21 November 2019

DOC19/1020120

Coffs Harbour Bypass (SSI-7666)

Figure 2-9 Kororo Public School bus interchange visualisation looking north-east

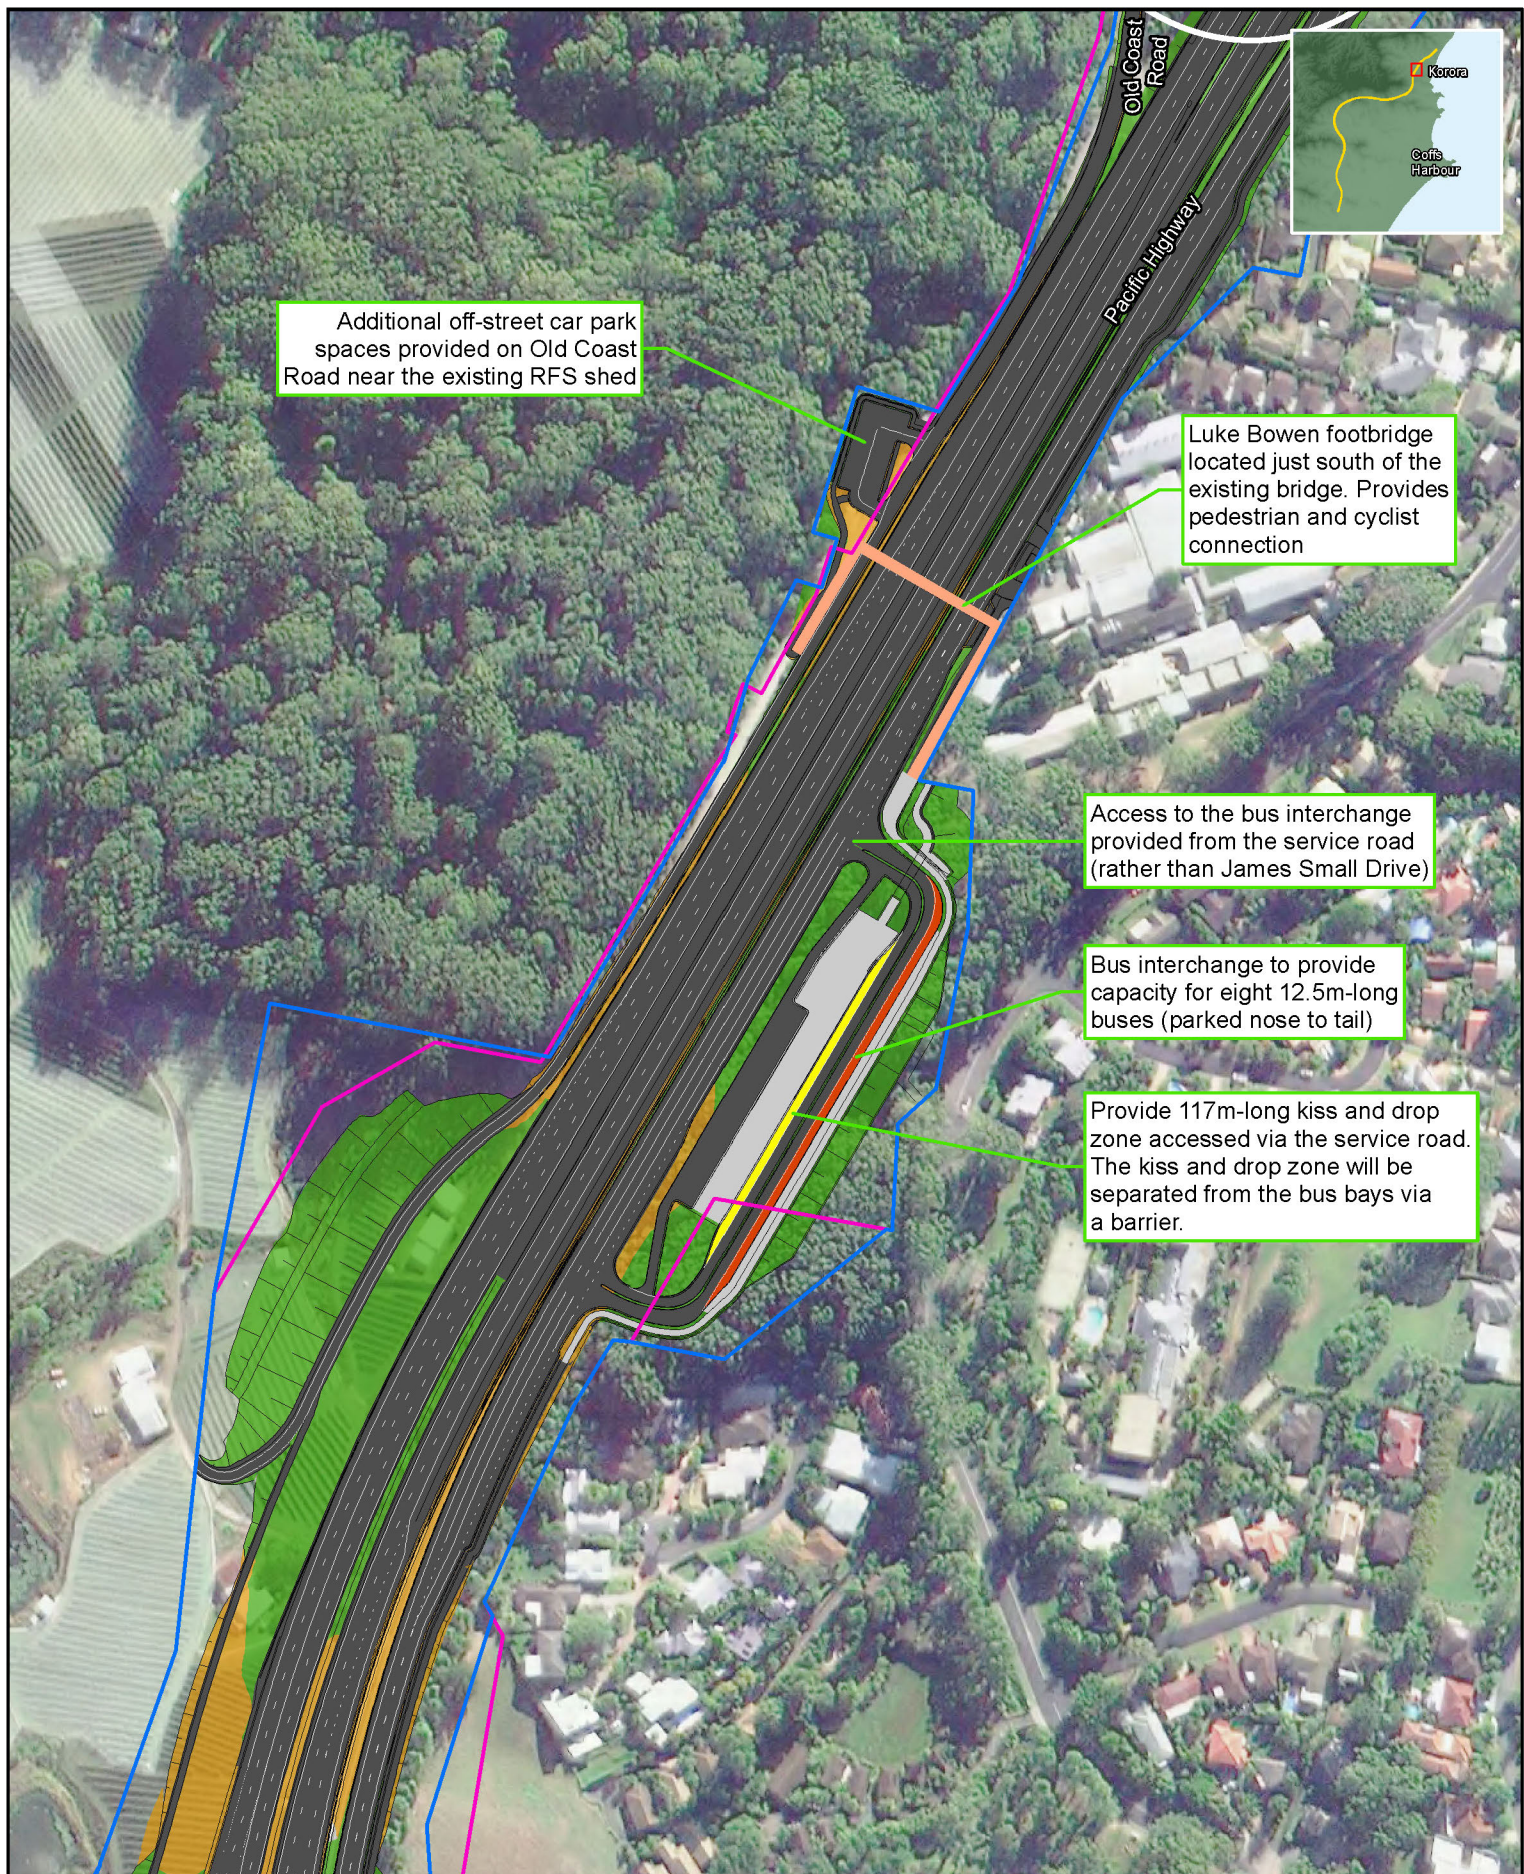
- relocation of Kororo Public School bus interchange from the Pacific Highway slip road to James Small Drive, a relatively narrow local road immediately to the east of the School;
- demolition / replacement of Luke Bowen Bridge over the Highway. It is noted that the new bridge is proposed to be located some 250 metres north of its current location, thereby increasing the distance from the School;
- closure of Korora School Road and construction of a new service road, including parking;
- changes to local traffic conditions during the construction phase and associated safety concerns;
- construction noise and associated disruption; and
- Impacts on air quality during the construction phase.

In addition, to further manage the potential impacts of the proposal, SINSW requires DPIE require the Applicant to engage in ongoing consultation with the Korora Road Public School to ensure:

- (i) the final location of the pedestrian bridge is located as close to the school as possible; and
- (ii) safe and accessible access is provided between the school and the new bus interchange.
